Our ref: NO/2018/111175/02-L01
Your ref: 3/2018/0750
Date: 20 December 2018

CHANGE OF USE OF REDUNDANT BARN TO FORM ONE UNIT OF RESIDENTIAL ACCOMMODATION

TWITTER BRIDGE FARM BARN, TWITTER BRIDGE FARM, TWITTER LANE, WADDINGTON, BB7 3LG

Org N^o 415/2/5
 Rev. C

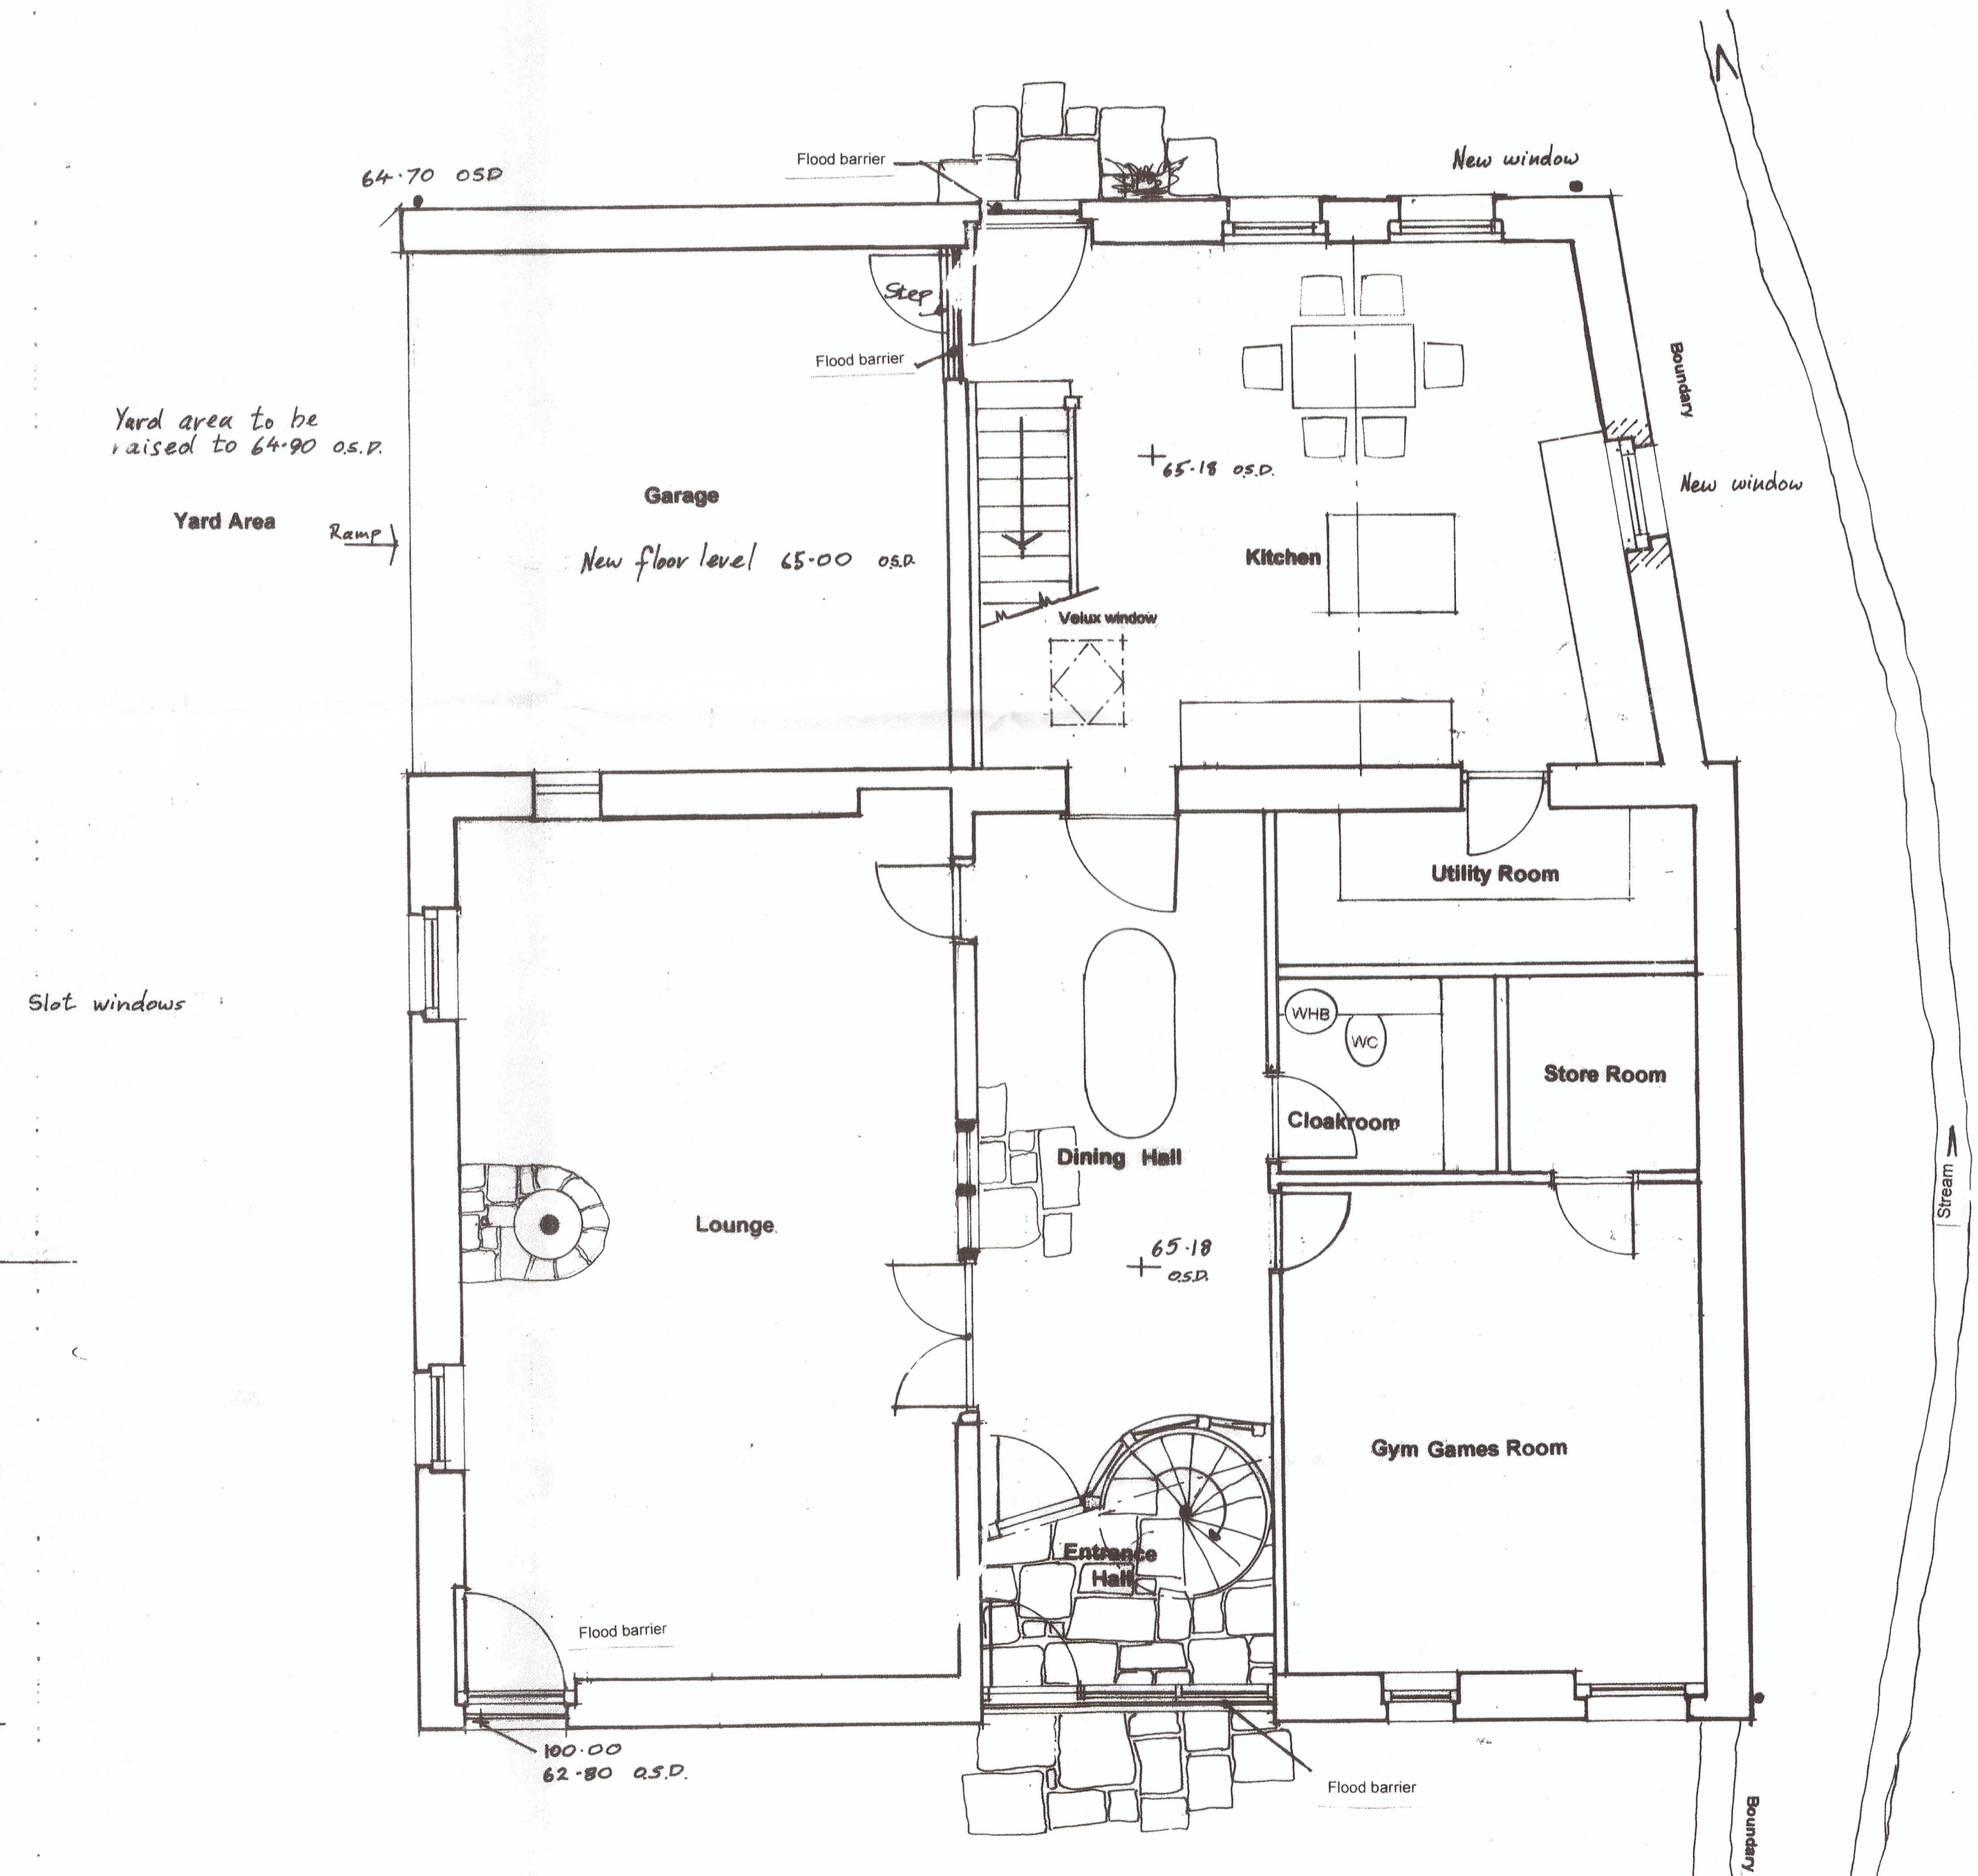
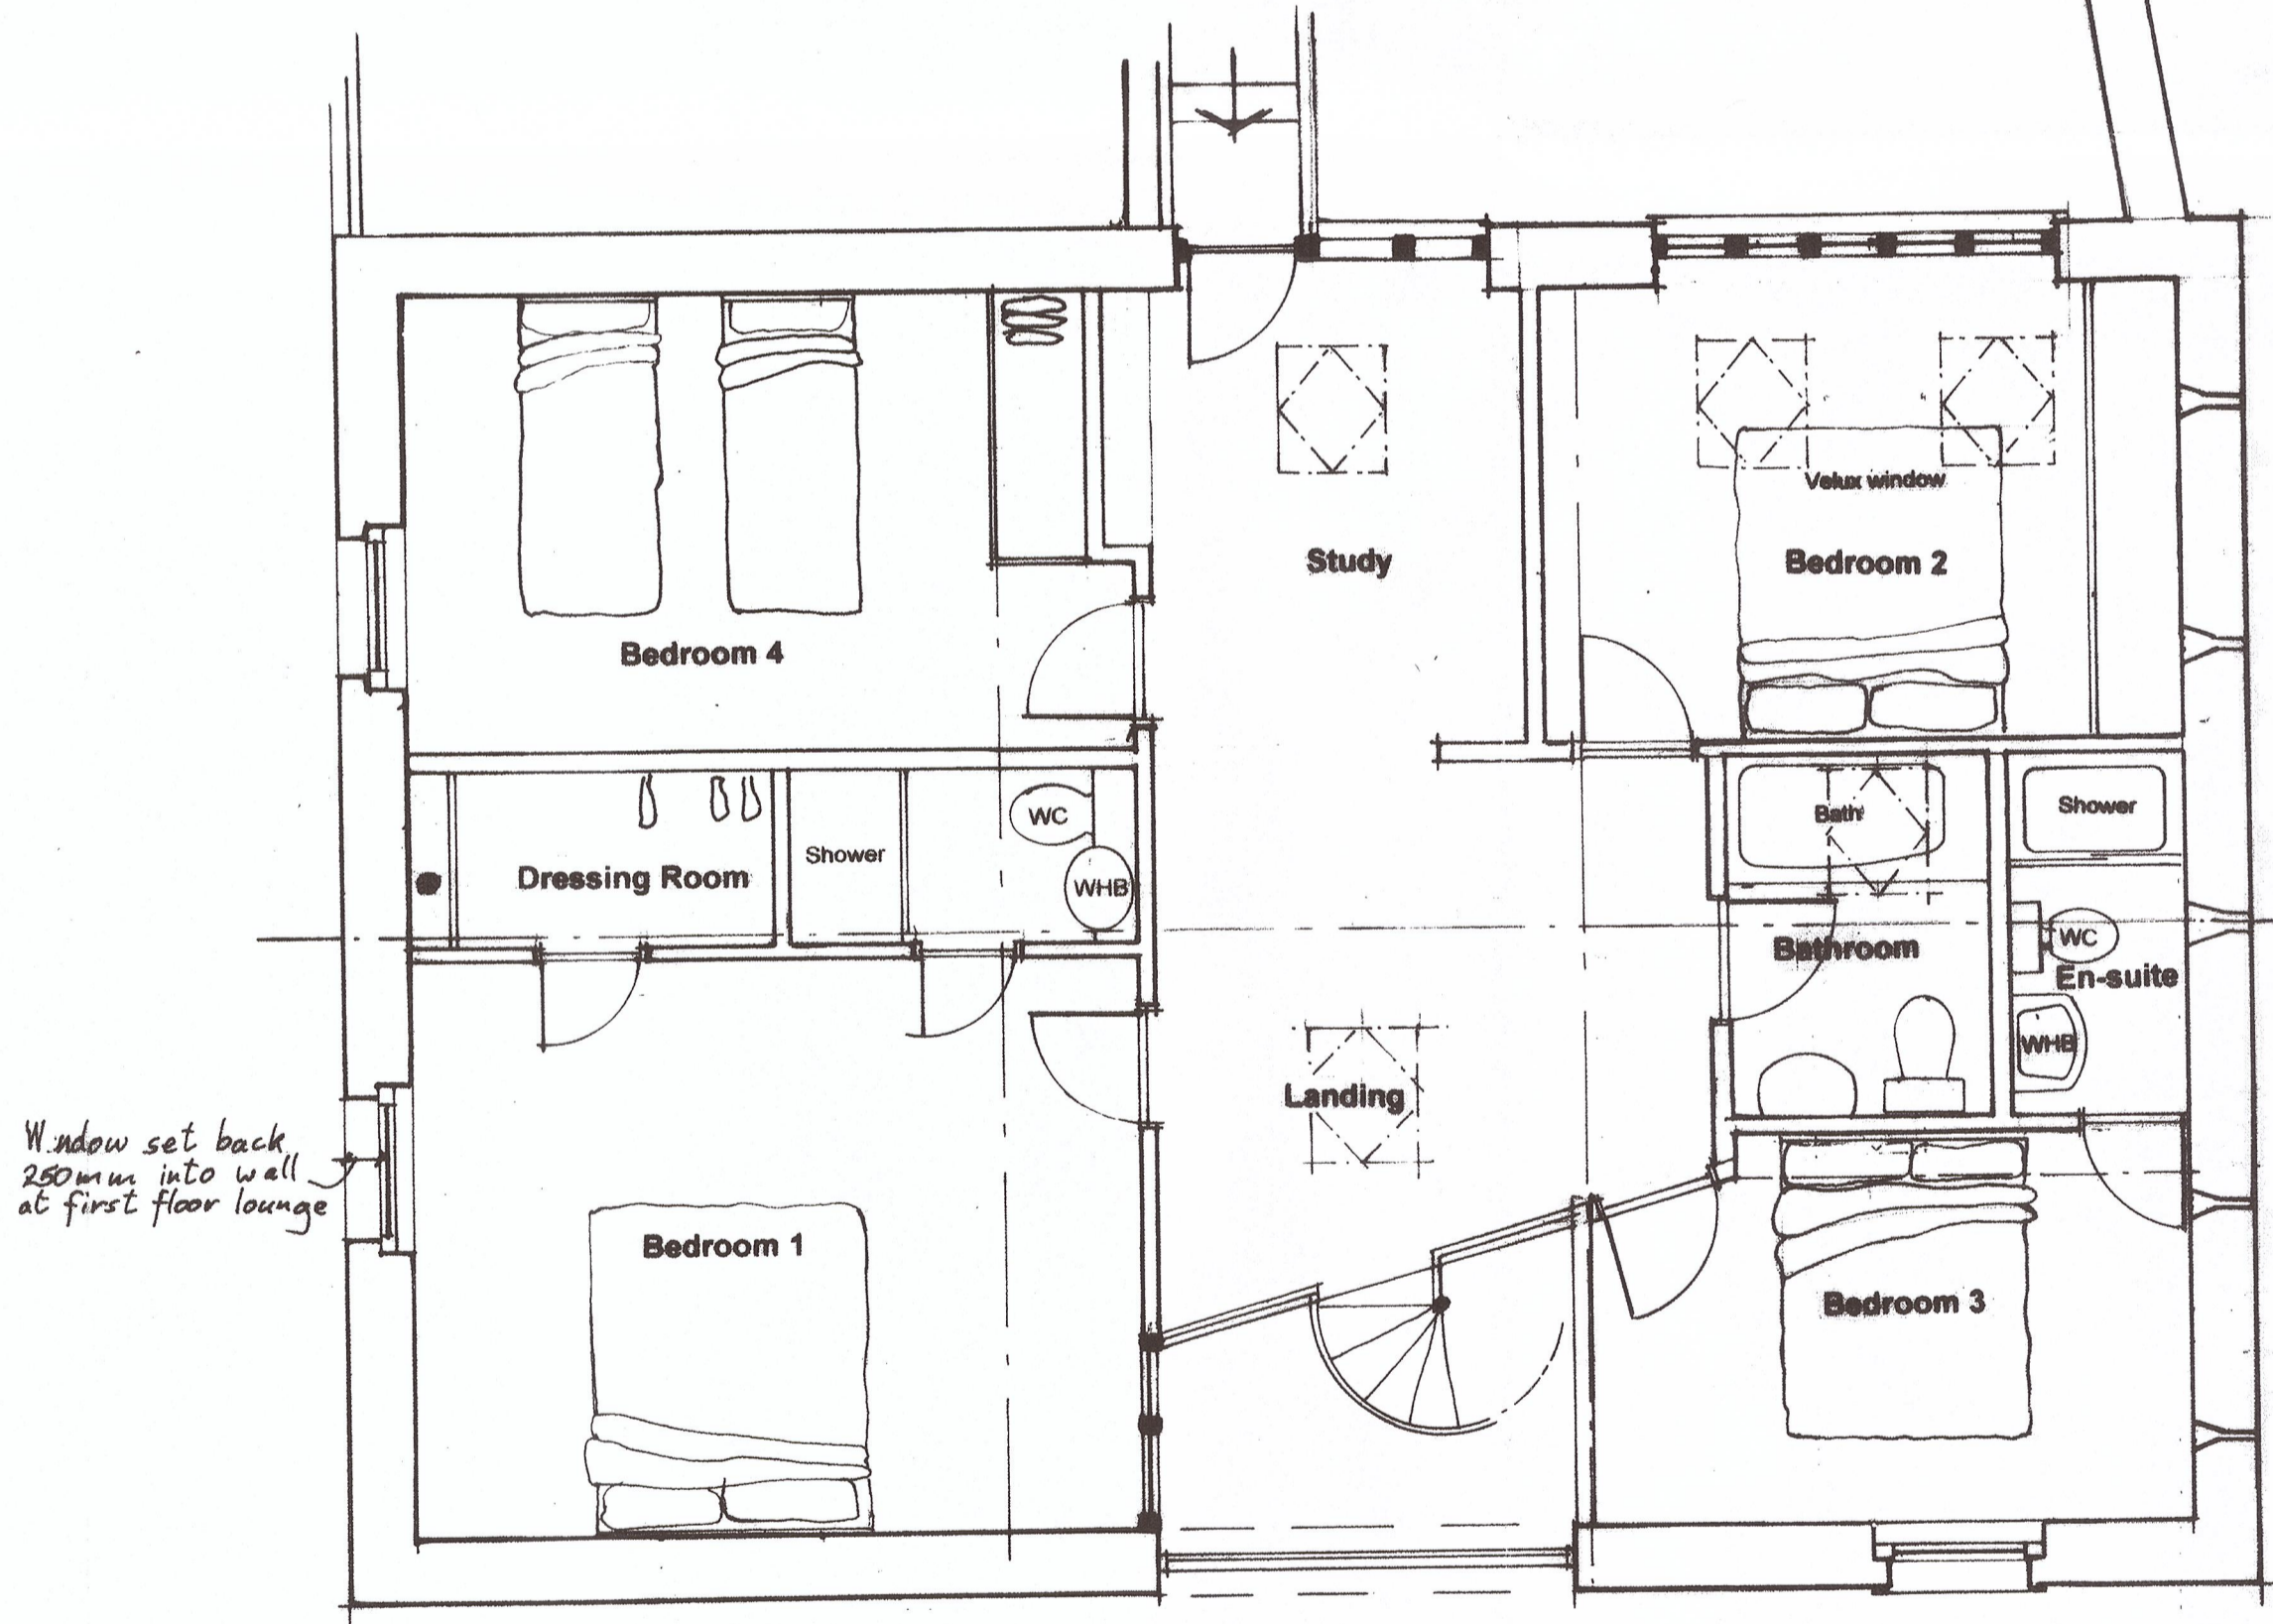
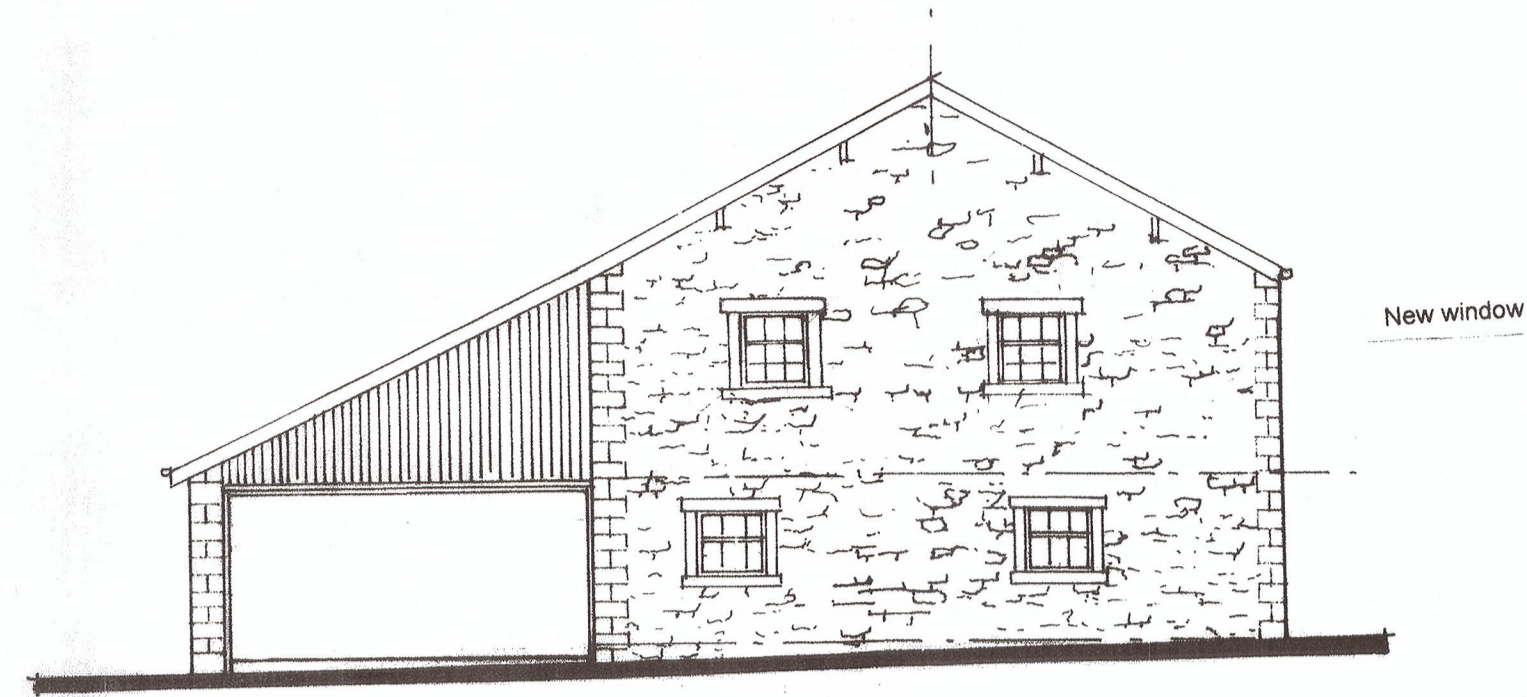
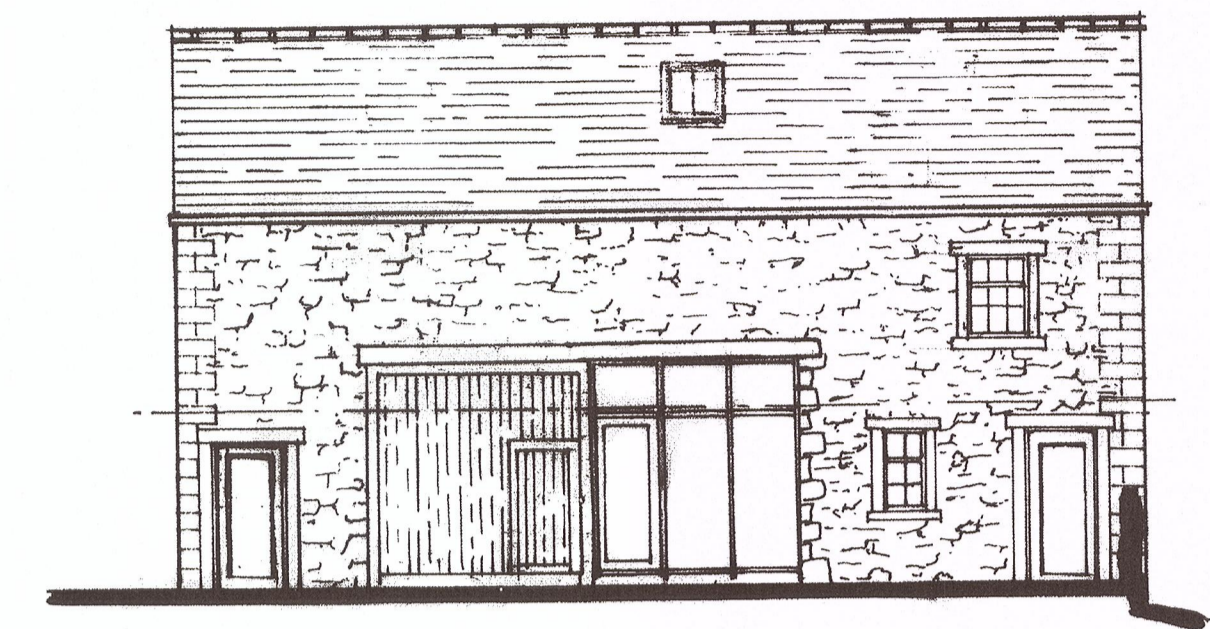
Thank you for re-consulting us on the above application, on 10 December 2018. The following revised plans and additional flood risk information has been submitted:

- Revised proposed plans and elevations (drawing no. 415/2/5/C)
- Revised site layout and curtilage area (drawing no. 415/2/3/B)
- Letter, which includes an additional flood risk assessment, dated 5 November 2018, prepared by Jeff Marshall and Associates.

We have reviewed the revised plans and additional flood risk information and we are satisfied that it has been demonstrated that the proposed development will not be at an unacceptable risk of flooding or exacerbate flood risk elsewhere. We therefore withdraw our previous objection, dated 12 October 2018.

However, we wish to point out that the additional flood risk assessment does not confirm the finished floor level to metres above Ordnance Datum, as previously requested. In this particular case, as the building is on the edge of Flood Zone 2 and 3 and we have no modelled flood level data available for this location, we are satisfied that the dwelling would not be at an unacceptable risk of flooding if the proposed mitigation measures are implemented.

The proposed development must therefore proceed in strict accordance with the additional flood risk assessment, included in the letter dated 5 November 2018 prepared

by Jeff Marshall and Associates, and the mitigation measures identified as it will form part of any subsequent planning approval. Any proposed changes to the approved FRA and / or the mitigation measures identified will require the submission of a revised FRA as part of an amended planning application.
